Del's Hidaway

Administrative Amendment Request

Project #PR 2020-004225 SI-

Transportation Development Comments:

SITE PLAN
1" = 30'-0"

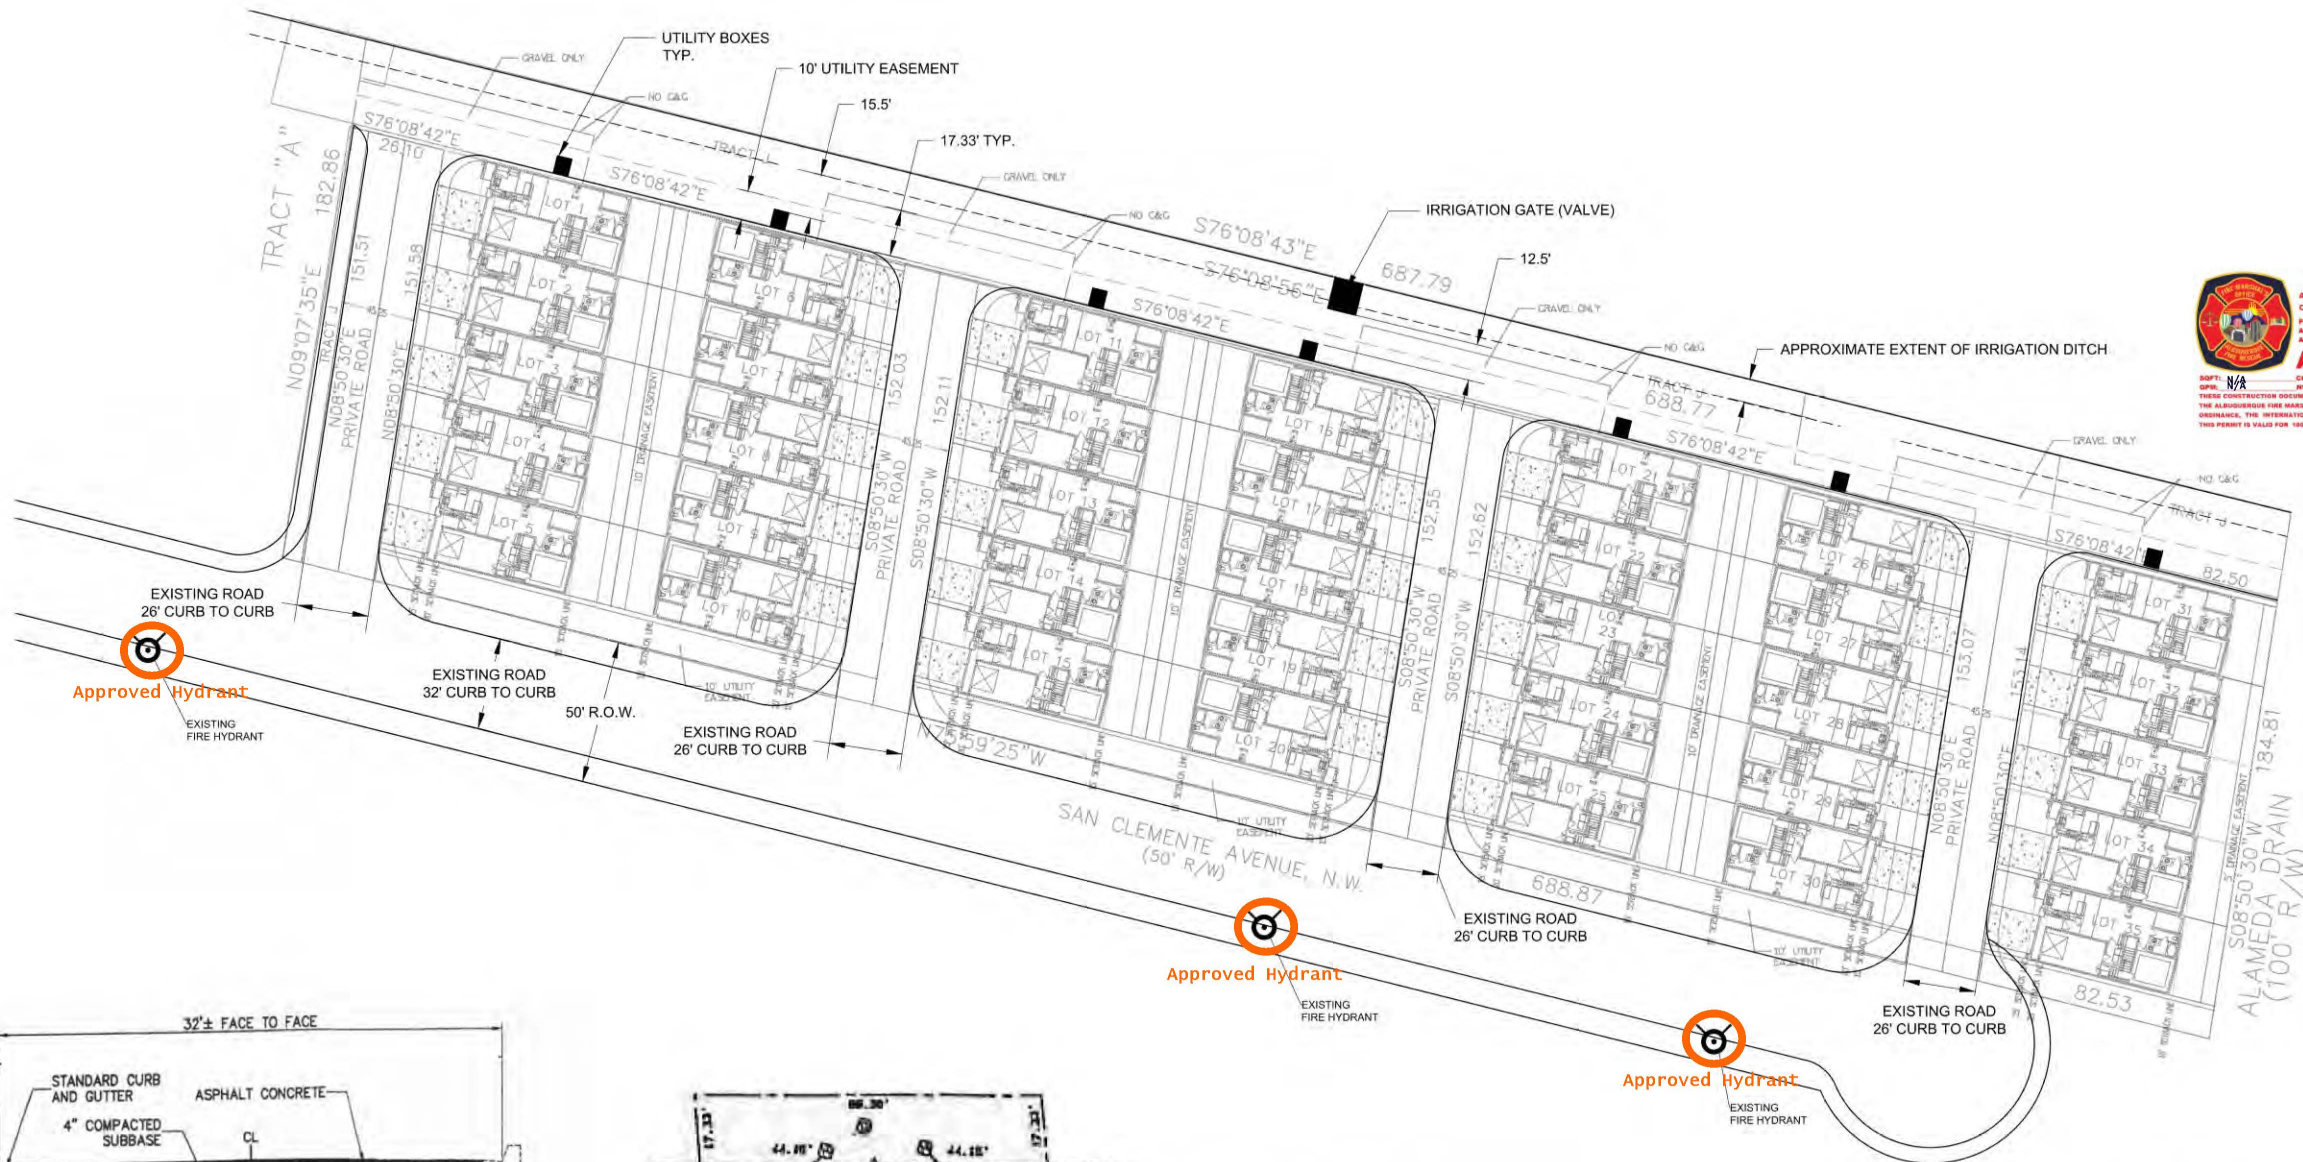
- Obtain Solid Waste and Fire Marshall approval for the proposed site plan.
- Since site plan was approved, requirements for turn-arounds have changed for trucks. Additional surfacing for the hammerheads appears to be needed. Refer to drawing below for required dimension for a turn-around.

- Provide plat indicating any private easements with the submittal. Accessways would need to be contained within these easements.
- Show sidewalk and sidewalk width along San Clemente and along any private easements. Per DPM, sidewalk is required along both public right-of-way and private easements serving multiple lots.
